Our reference: ECM 9511657
Contact: Gavin Cherry
Telephone: (02) 4732 8125

25 March 2021

**Request for Comments – SSD-10448 – Aspect Industrial Estate, Lots 54-58
DP 259135, 788-882 Mamre Road, Kemps Creek**

TYPICAL SECTION - ESTATE ROAD 01

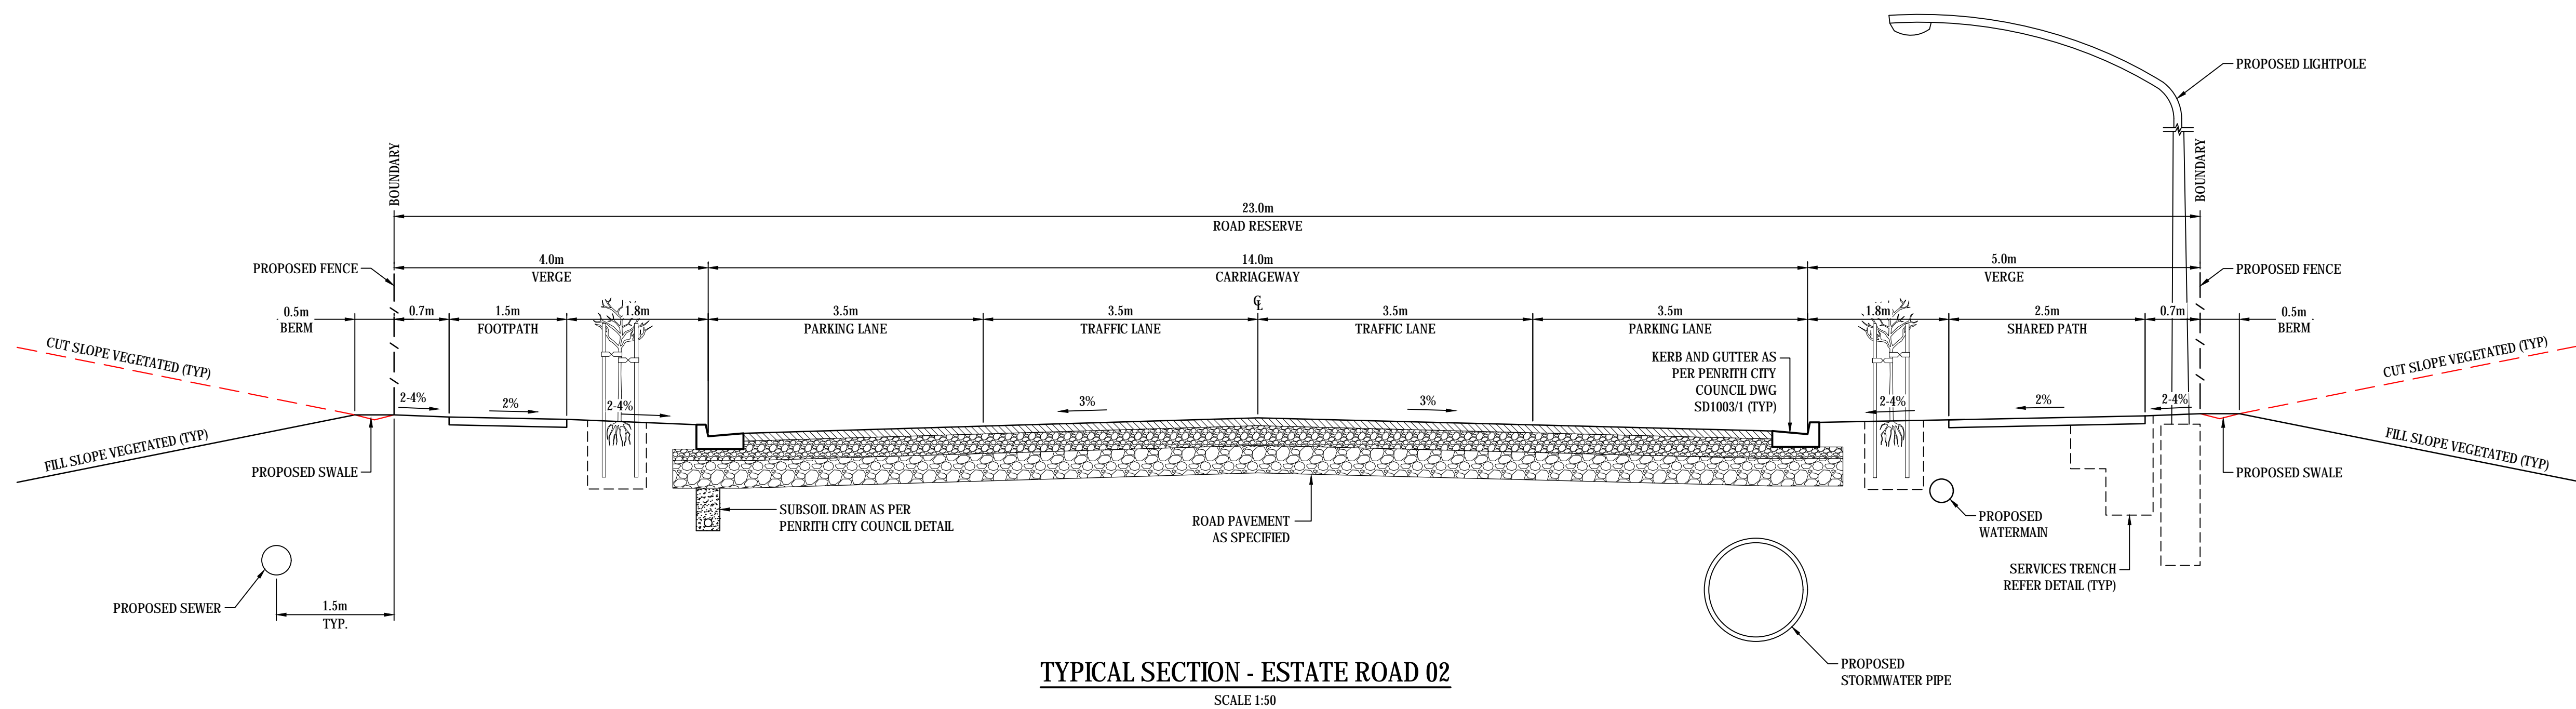
- It is acknowledged that the road reserve width of 26.4m (mid-block) for Access Roads 01 & 03 is in accordance the Draft MRP DCP for a *Distributor / Collector Road*. A central median is to be provided to Access Roads 01 & 03 in accordance with Figure 13 of the Draft MRP DCP. Road pavement and verge widths shall be in accordance with Figure 13 of the Draft Mamre Road Precinct Development Control Plan.

- Estate Road 01 shall be designed as a *Distributor / Collector Road* with a 26.4m wide road reserve (mid block) and 30.6m wide road reserve (at intersections) with associated pavement widths, central median widths and verge widths to be in accordance with Table 9 and Figure 13 of the Mamre Road Precinct Draft Development Control Plan.

TYPICAL SECTION - TEMPORARY TURNING HEAD

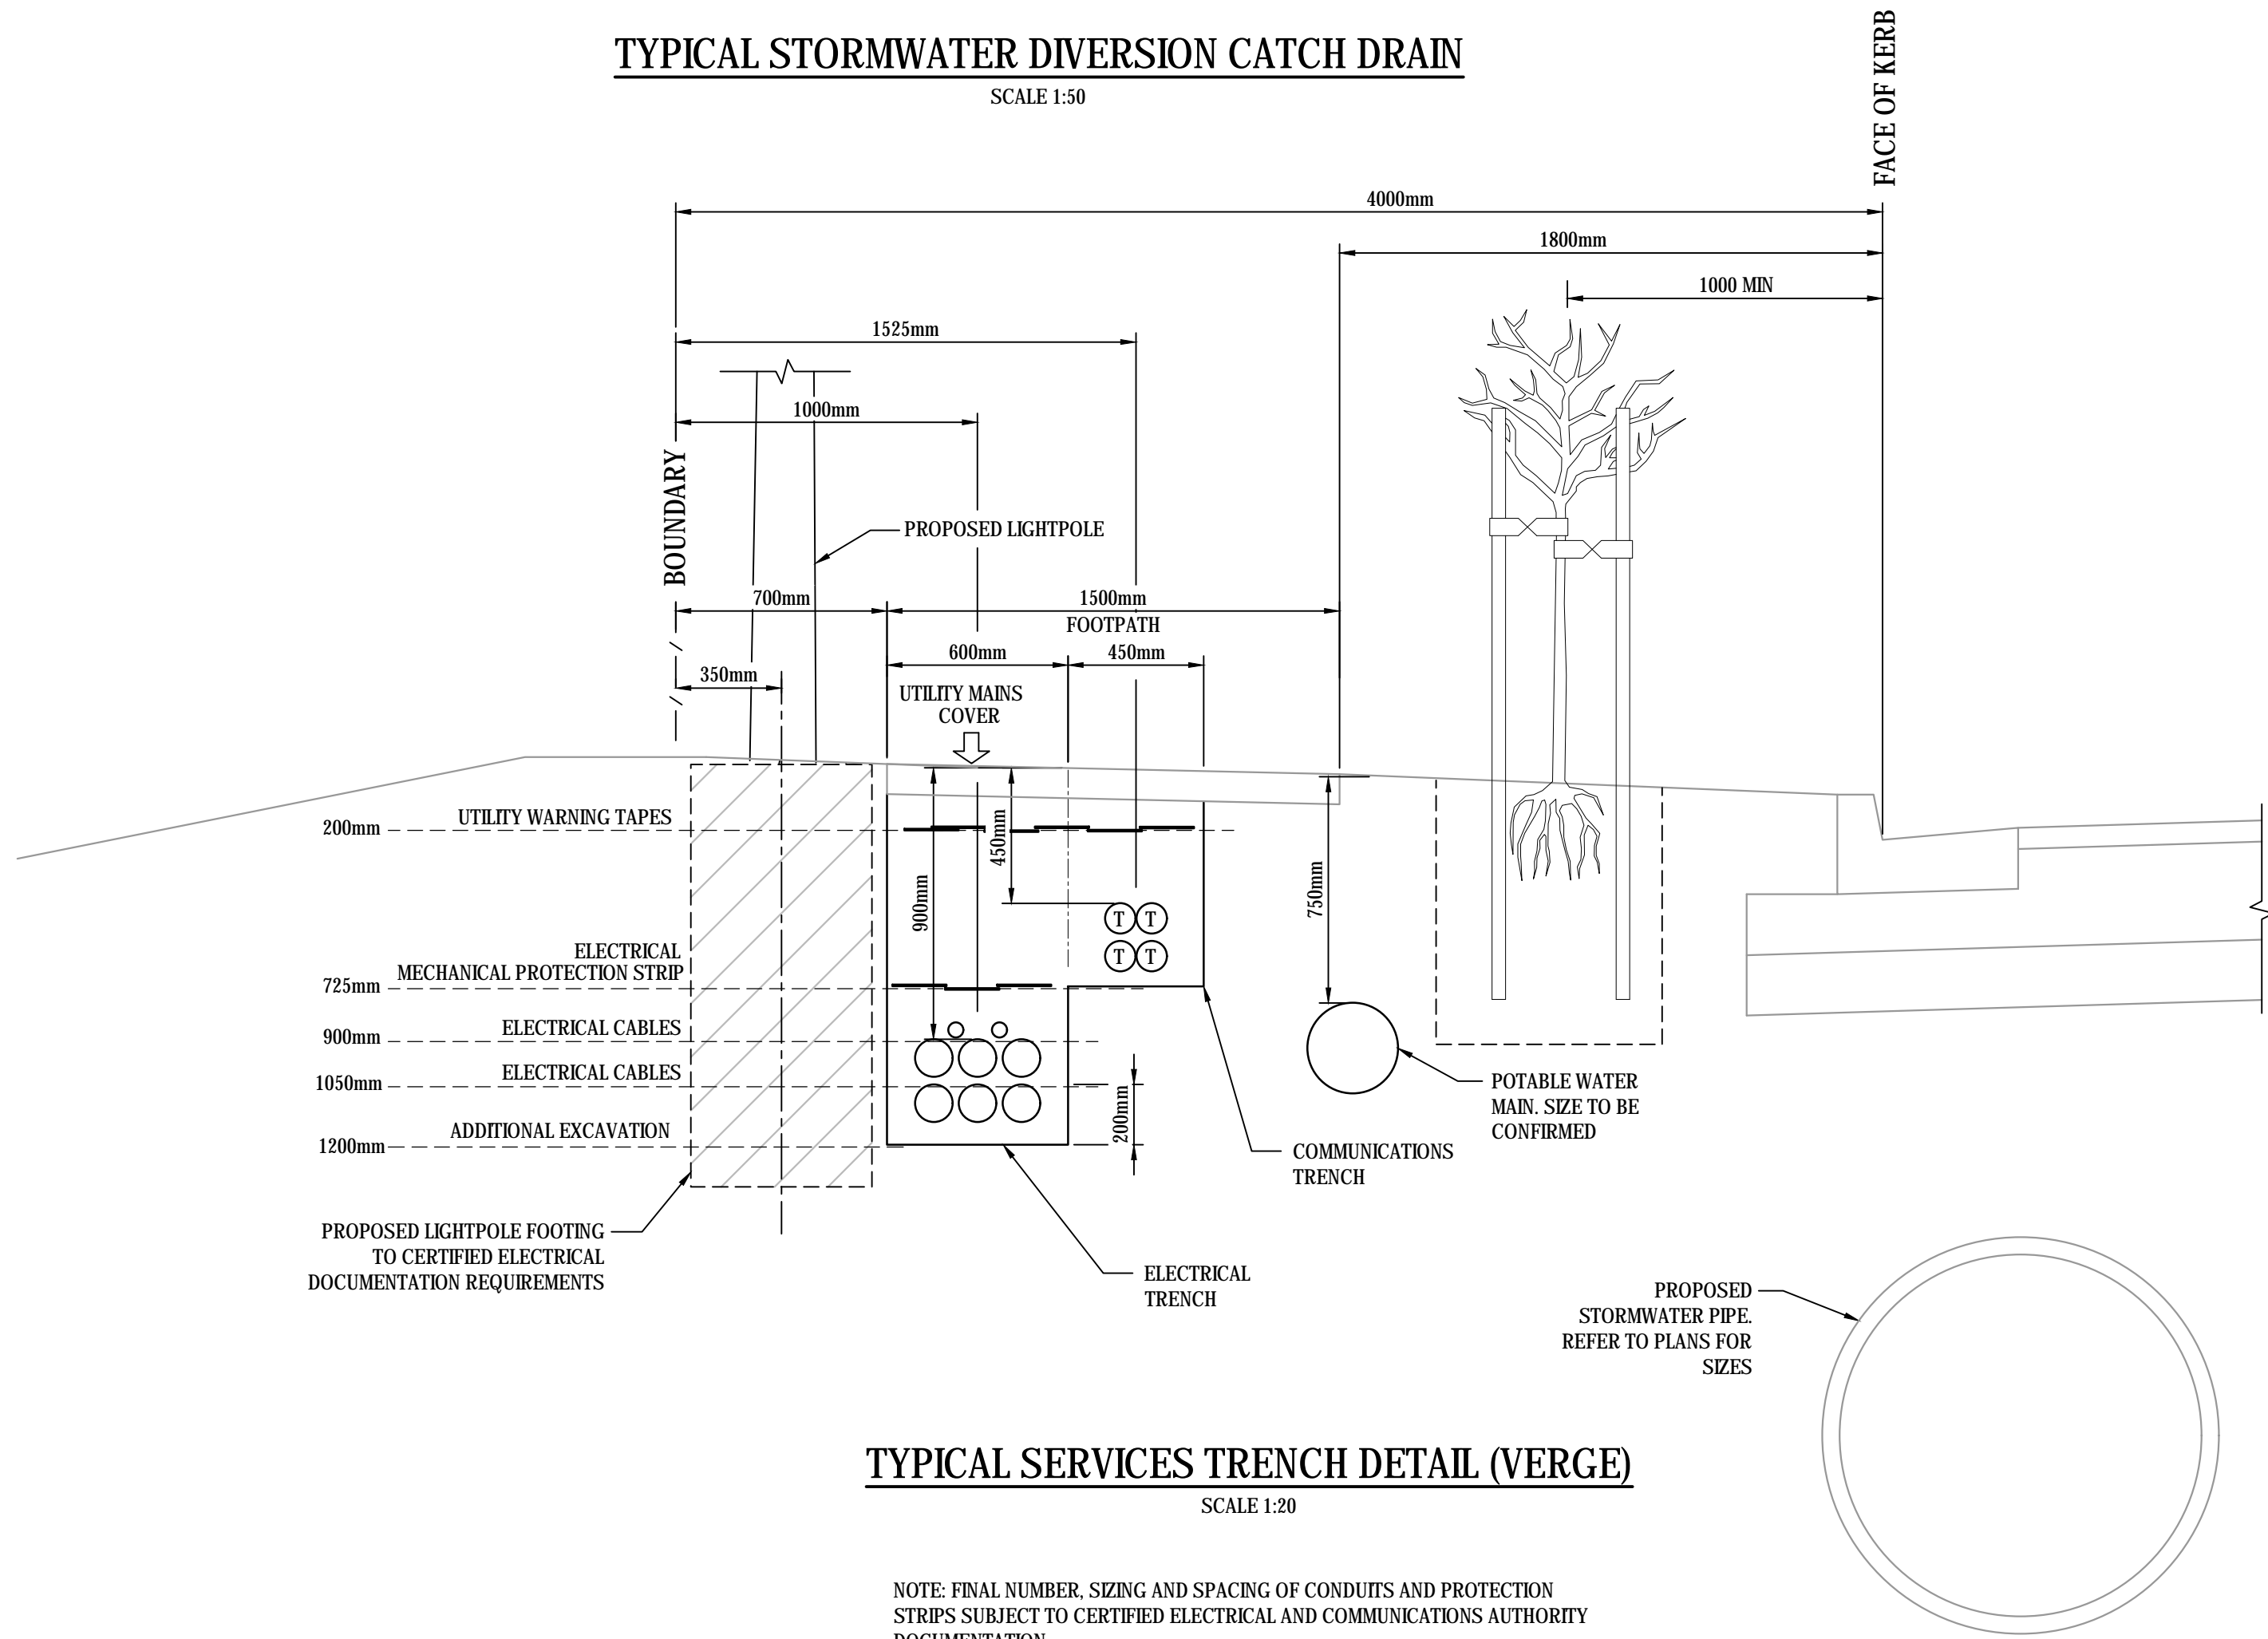
- Vehicular access, including heavy vehicle access, is also proposed onto Access Road 3 (Distributor Road) for warehouses 4, 5, 6 & 8 and is also not supported. Alternative vehicular access for warehouses 6 and 8 is available from Access Road 4. Vehicular access for warehouses 4 and 5 shall be a left-in / left-out type arrangement as Access Road 3 requires provision of a central median (Figure 13 and 14 of the MRP DCP). Vehicles leaving warehouses 4 and 5 will be able to turn around at the temporary cul-de-sac at the end of Access Road 3.

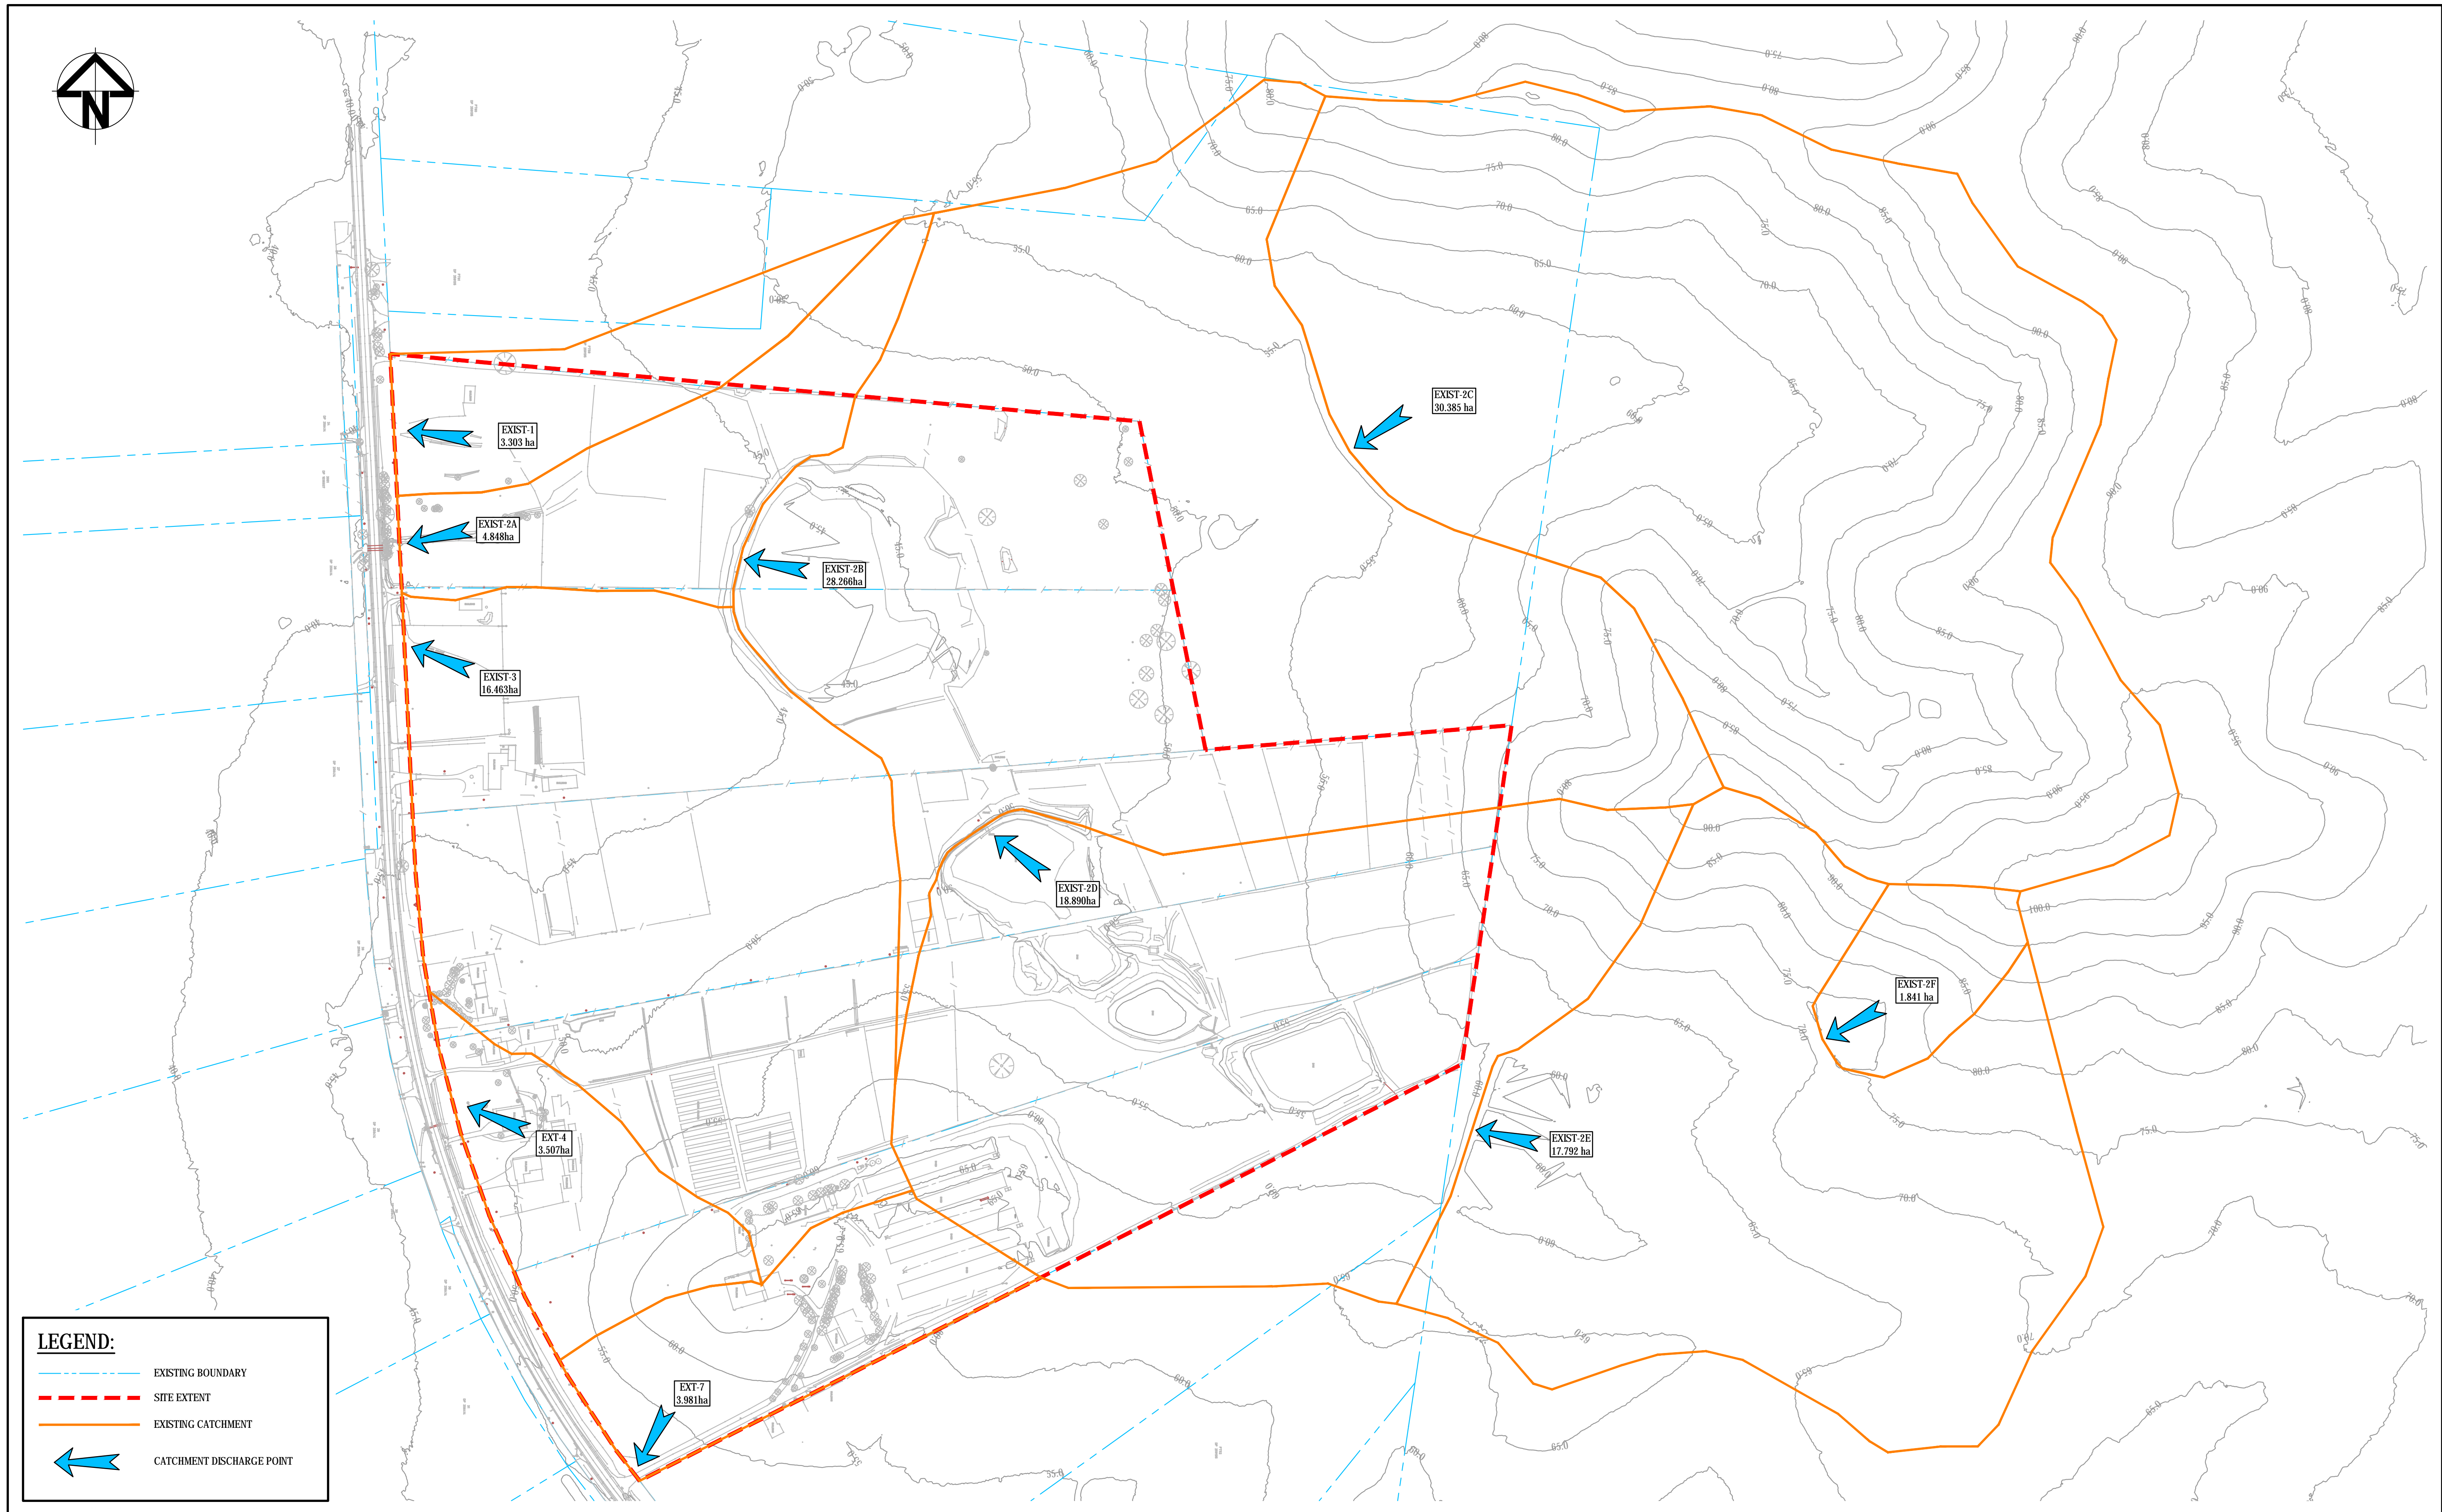
- In relation to the treatment of stormwater for the proposed development, it is proposed that a 1,600m² bioretention system pre-treated with an Ocean Save OS-2324 would be incorporated. The report proposes to the use of a proprietary filter media called Filterra. It is noted that only 1 GPT is shown but there are 2 inlets into the basin as shown on the drawing. It is also noted that drawing number 18-596-C1012 Issue 3 dated 15/10/2020 indicates that the top water level is 1.25 m above the filter layer as it is located within an OSD basin. This is not supported and needs to be clarified. In relation to the design of the basin, it is considered that a revised full set of engineering plans is required to be provided for review.

- In relation to the use of Filterra as an option, following a review of the supporting report provided, and noting that it is more widely permitted in other local government areas, no concerns are raised provided the treatment system is not dedicated to Council for ongoing ownership and maintenance. It would also need to be adequately conditioned to ensure that it was maintained by the developer in perpetuity. Prior to determination of the development proposal, it is suggest that additional details are required on the configuration of the basin, filter media area, depths of inundation etc, species and density of vegetation and provision of GPTs. These details should be included in an updated and full set of drainage plans.
